Project Title: DC I Southwest Mesa Building Permit #: _____ City Drainage #: K10D056
DRB#: _____ EPC#: _____ Work Order#: _____
Legal Description: Tract C-44B, Section 22N, T10N, R.2E, NMPM
City Address: 8217 Central Ave NW
Engineering Firm: Littlejohn Engineering Assoc. Contact: TONY HEATH
Address: 1935 21st Ave S, Nashville, TN 37212
Phone#: 615.385.4144 Fax#: 615.385.4020 E-mail: theath@smeinc.com
Owner: Dialysis Clinic Inc. Contact: Jack Freeman
Address: 1633 Church St, Suite 500
Phone#: 615.329.2424 Fax#: _____ E-mail: jack@jfreemanassoc.com
Architect: Jack Freeman & Assoc. Contact: Jack Freeman
Address: 311 22nd Ave N, Nashville, TN 37203
Phone#: 615.329.2424 Fax#: _____ E-mail: jack@jfreemanassoc.com
Other Contact: _____ Contact: _____
Address: _____
Phone#: _____ Fax#: _____ E-mail: _____

DCI Southwest Mesa

From: Carrillo, Abiel X.
Sent: Wednesday, September 14, 2016 12:17 PM
To: 'theath@leainc.com'
Subject: DCI Southwest - K10D056 - Stamp Date 8-3-2016

RE: **DCI – SW Mesa, T201692131**
Littlejohn Project No. 20150430

DUMPSTER PAD
WITH SCREEN FENCE
NOT TO SCALE

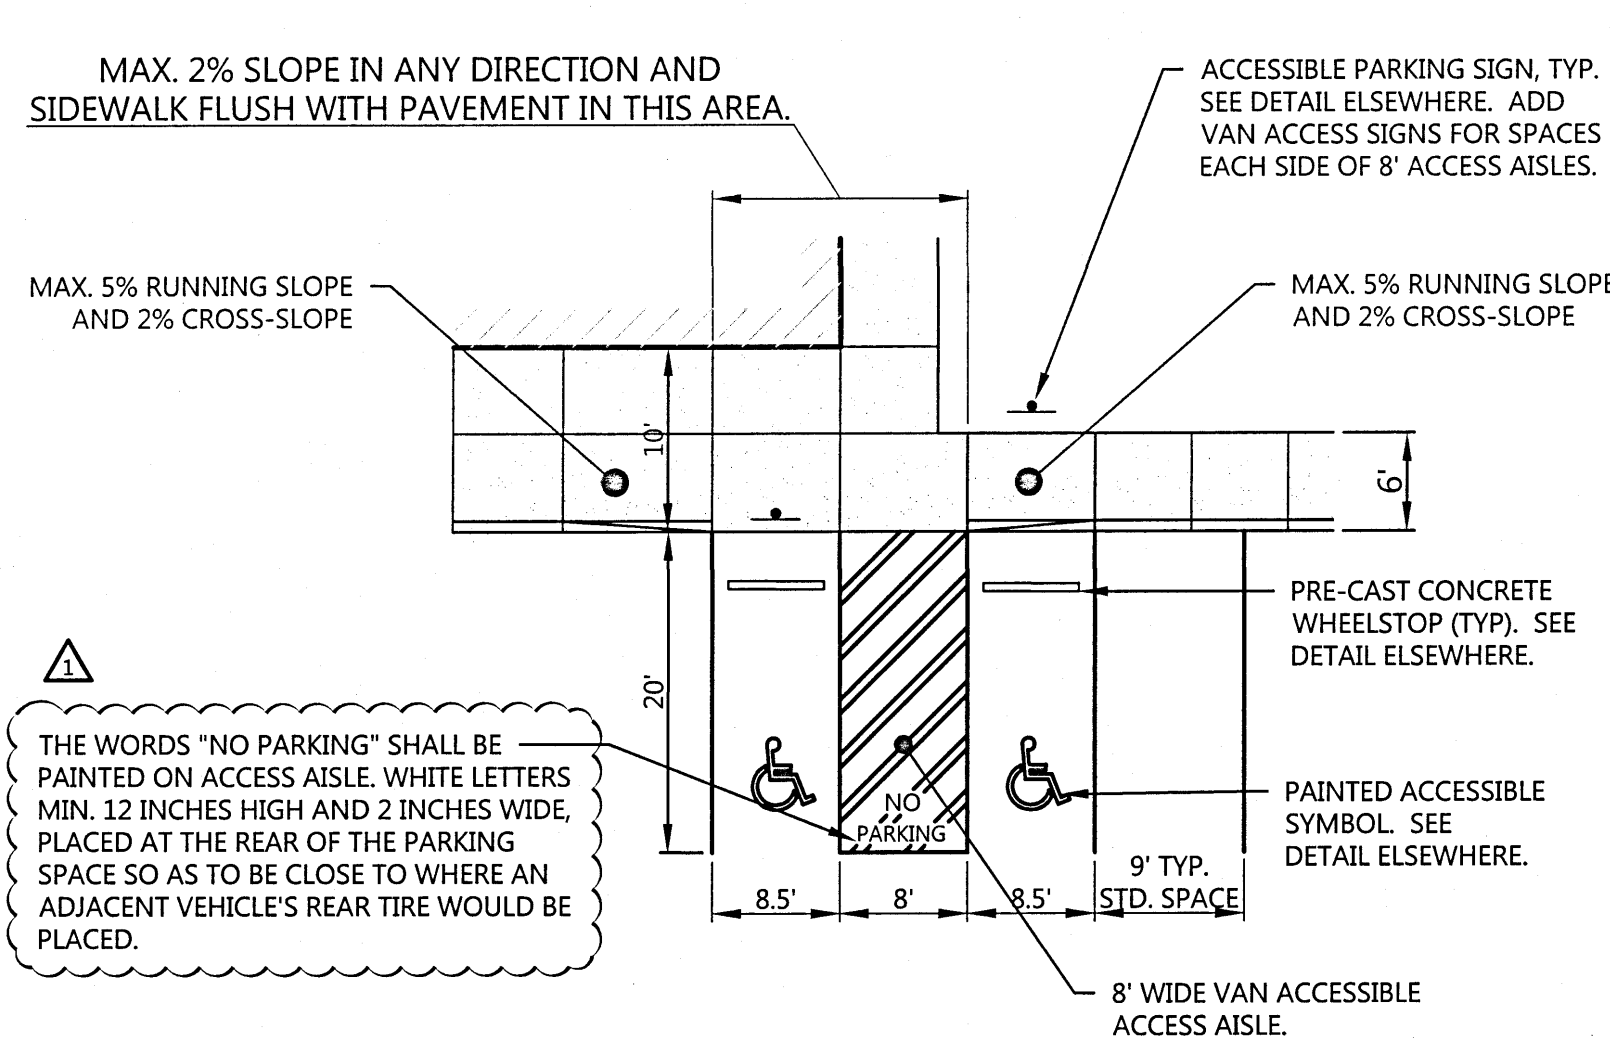
1. Comment: CO IS REQUIRED DISAPPROVED ADRIAN MAREZ 8-24-16. BOTH CONCRETE SLAB AND APRON 6INCHES THICK 4000PSI 3/4AGGREGATED WITH 6X6-10/10 WWM OR EQUAL. RAISED PAD AS INDICATED NOT RECCOMENDED. PAD DEMENSIONS12FT X 9FT 6'. APRON-12FT X 8FT .ALSO REMOVE BOLLARDS THAT ARE LOCATED JUST INSIDE FRONT OF ENCLOSURE. MUST HAVE CLEARENCE OF 12FT INSIDE TO INSIDE OF ENCLOSURE WHEN GATES OPEN. PLEASE SHOW DETAIL GATE PIN HOLES TO KEEP GATES OPEN AND CLOSED.NEED APPROVED SITE DEVELOPEMENT PLAN. REFER TO ZONEING COMMENTS. DRB SITE DEVELOPEMENT PLAN.

Response: We understand a certificate of occupancy is required by the building department certifying the building's compliance with applicable building codes and other laws. The dumpster pad has been revised per comments; See Sheet C4.00 Layout Plan and Sheet C7.00, Detail 13.

CONCRETE RIBBON CURB
W/ GRAVEL DIAPHRAGM
NO SCALE

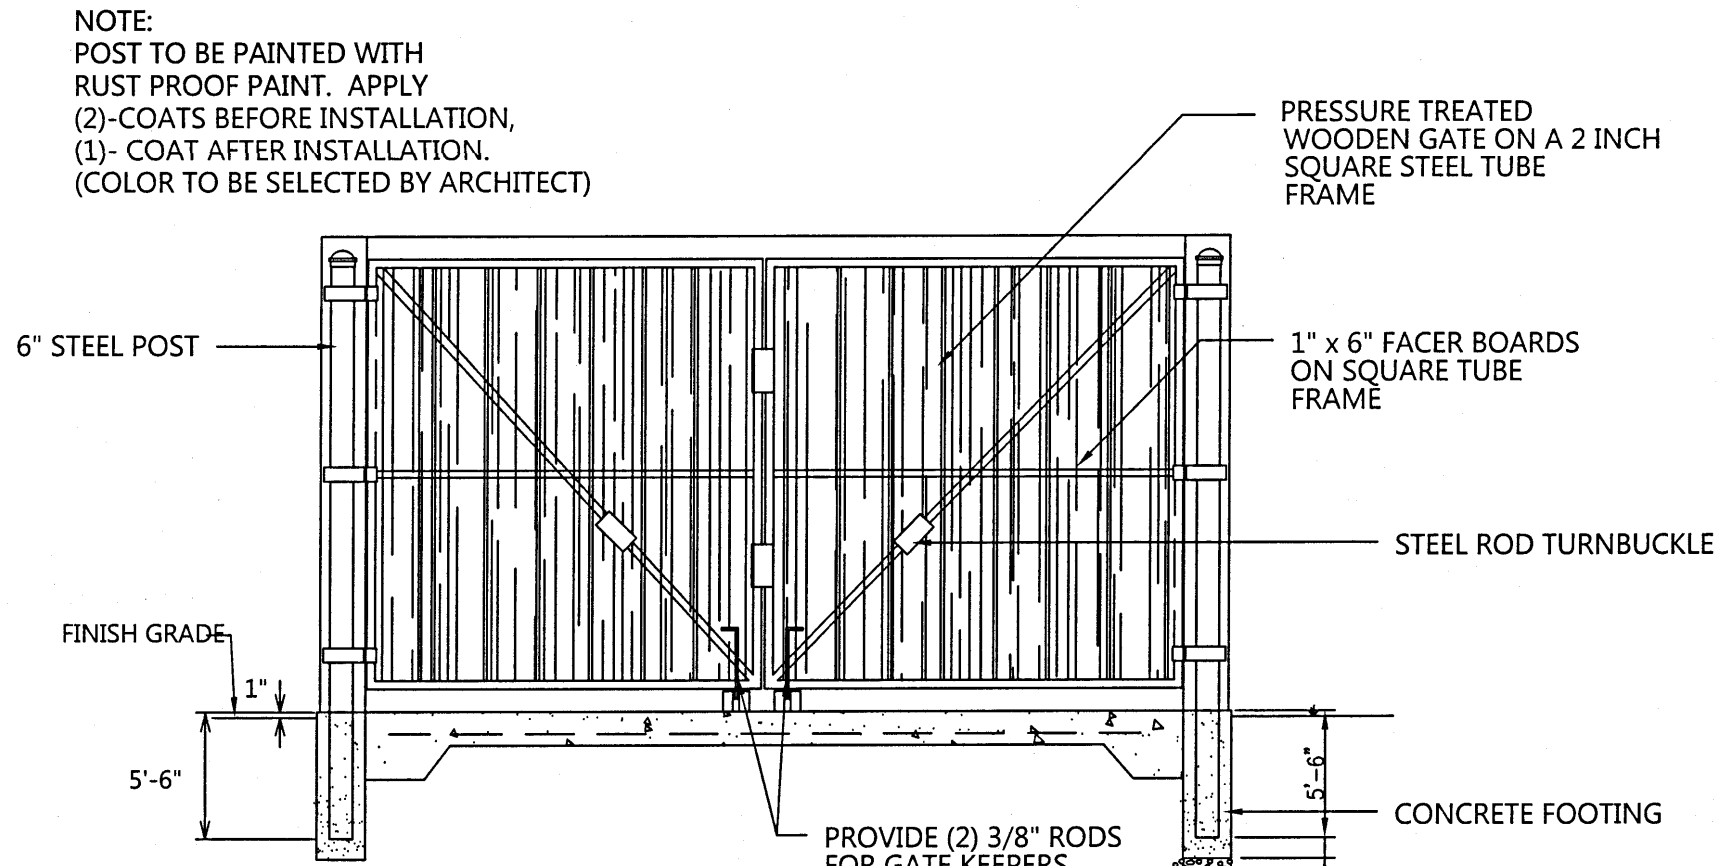
3. There appears to be a rundown missing from the parking lot along the south edge of the site to discharge the surface flows into the pond.
4. The apparent landscaping islands around the edge of the property should be graded to be self-contained (with a curb cut outlet if you feel it is necessary), or at least not draining to the adjacent properties, unless there is a drainage easement in place.

Response: The south edge of the parking lot has a ribbon curb w/ gravel diaphragm to discharge surface flows into the pond. See detail 3A on Sheet C7.00.

date
August 3, 2016
project no.
35-122
sheet no.
C4.00
LAYOUT PLAN

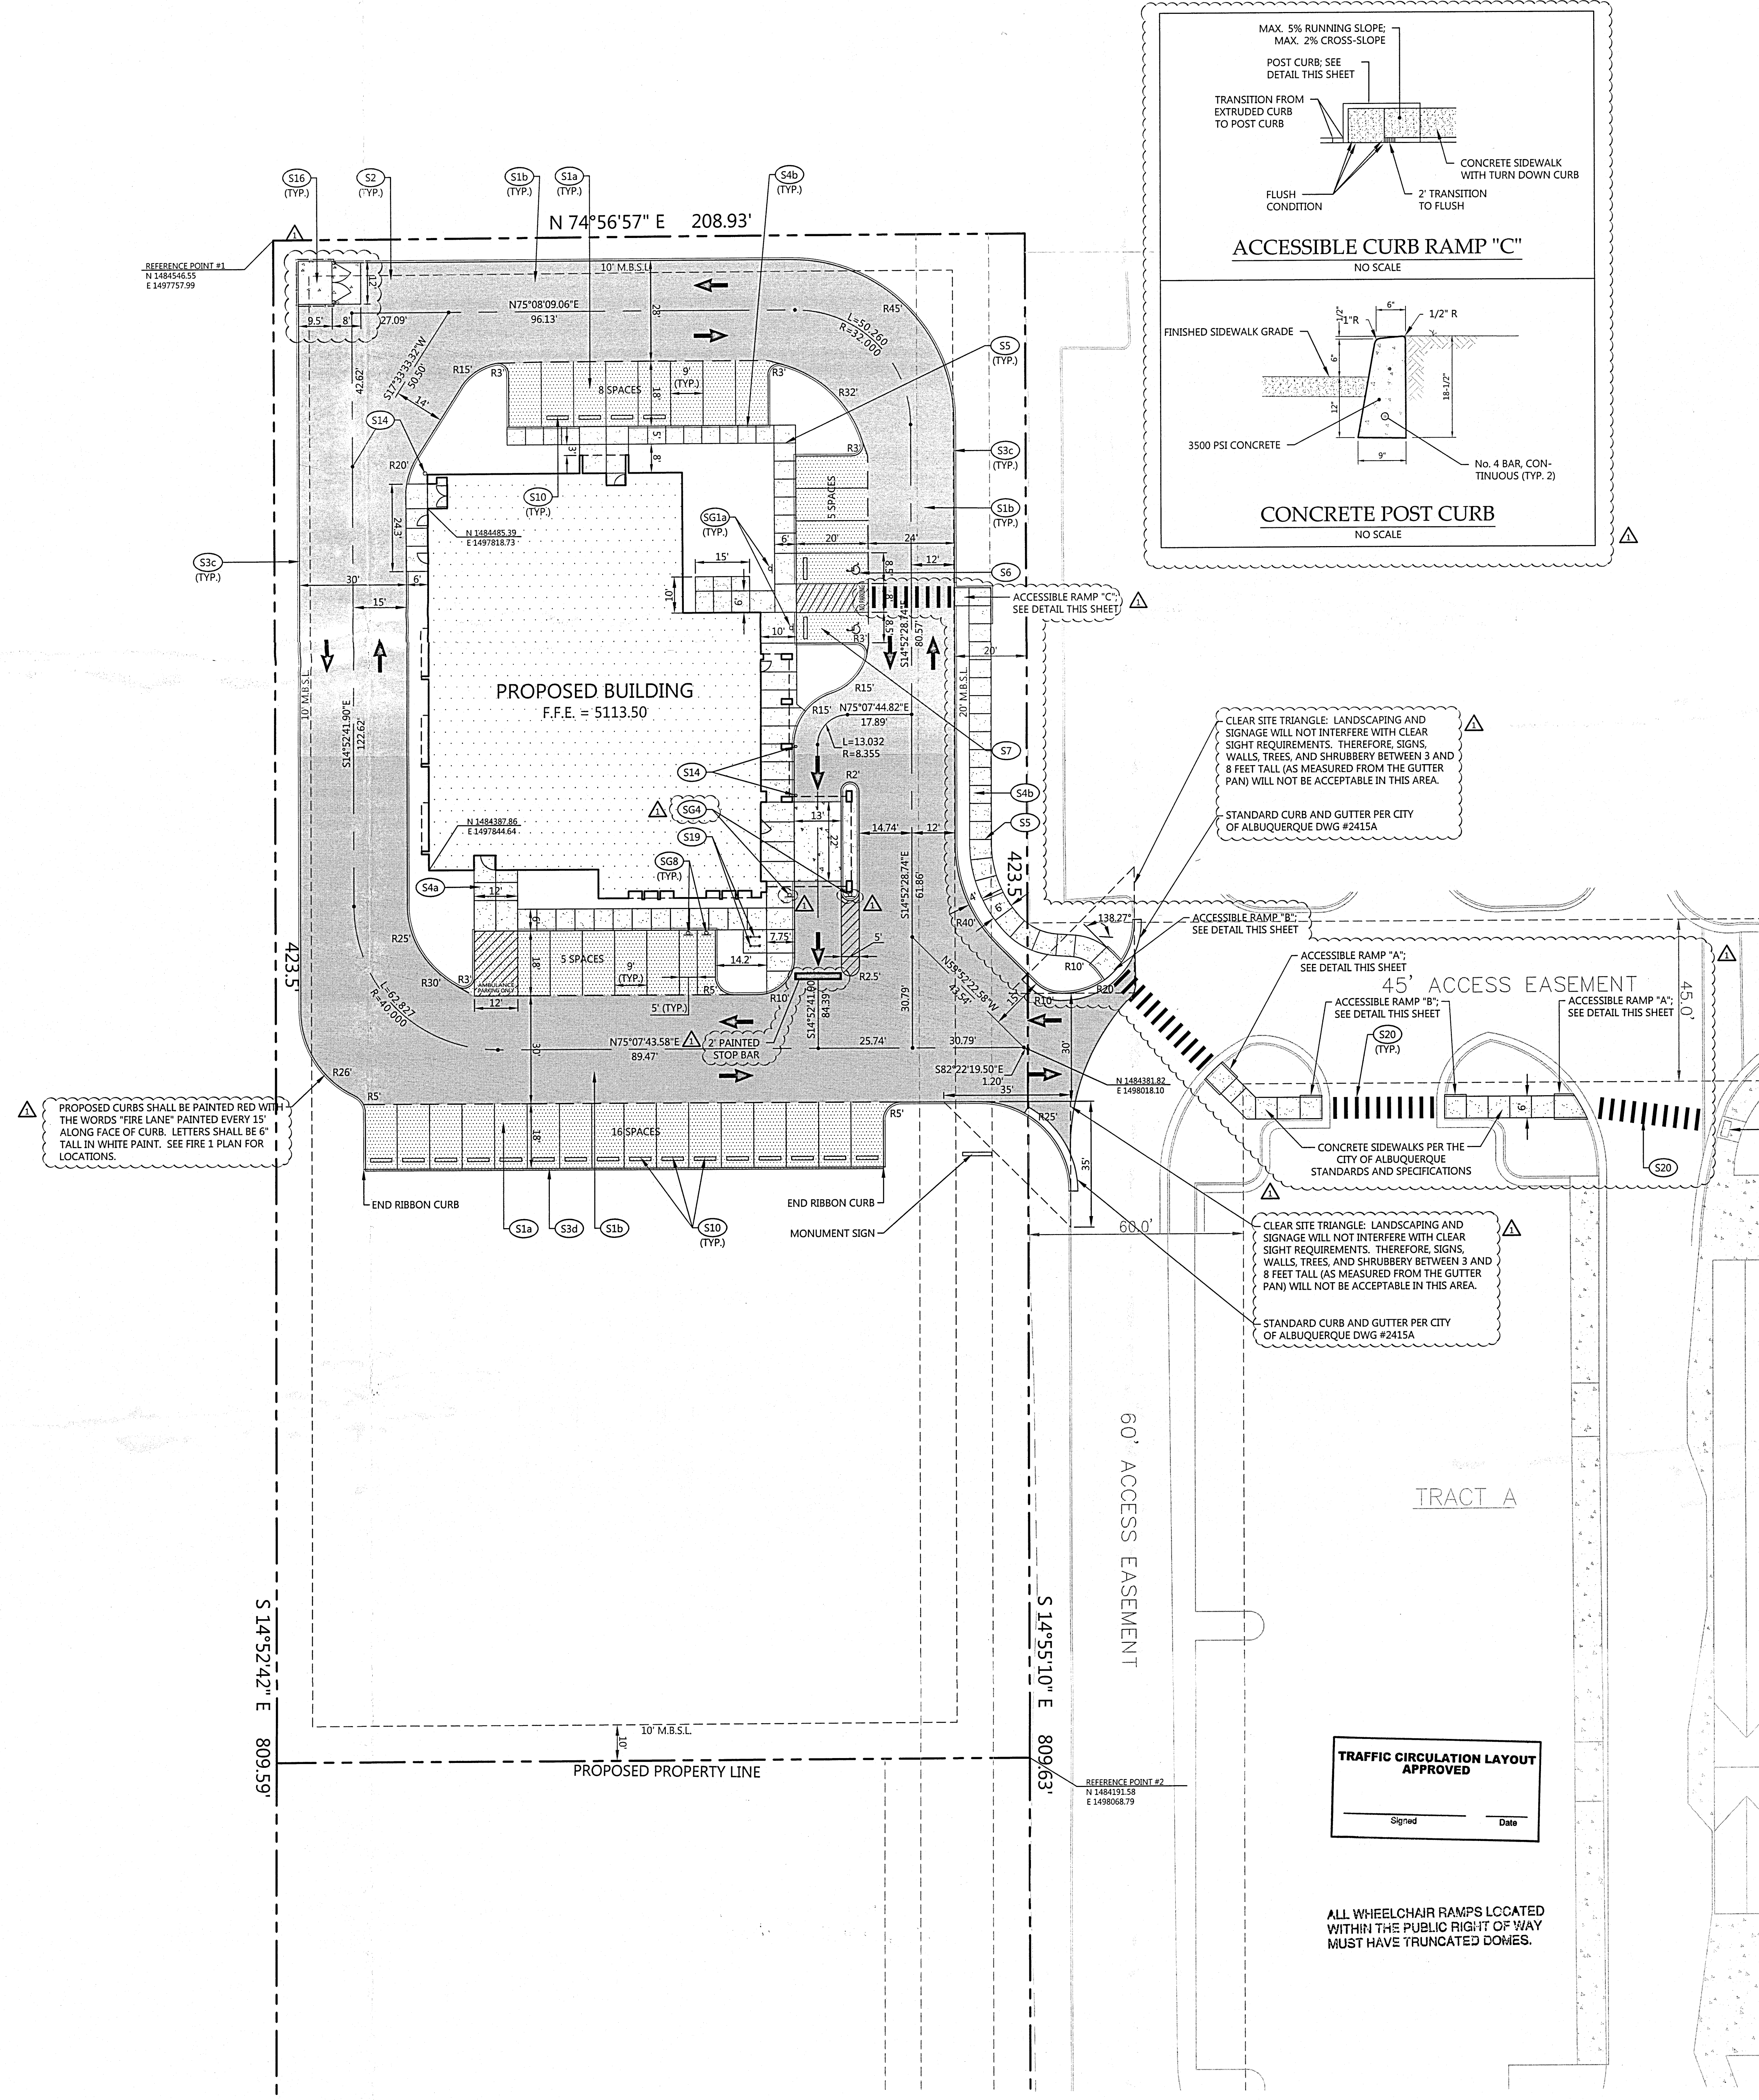
6. Minor comment: Please show a vicinity map in the resubmittal referencing the Zone Atlas Map Number and if the site is affected by any floodplains.

1. Comment: CO Required. Provide a complete copy of the DRB Site development plan attached to the document folder. Provide Replat. Address correction needed. Pending full review.

Response: Vicinity map and zone atlas information has been included on sheet C4.00 with this submittal.

Response: We understand a certificate of occupancy is required. We will attached a complete copy of the previous DRB Site Development plan to the document folder. The plat has been included in this submittal. Address has been corrected on the title block and on Sheet C4.00 Layout Plan.
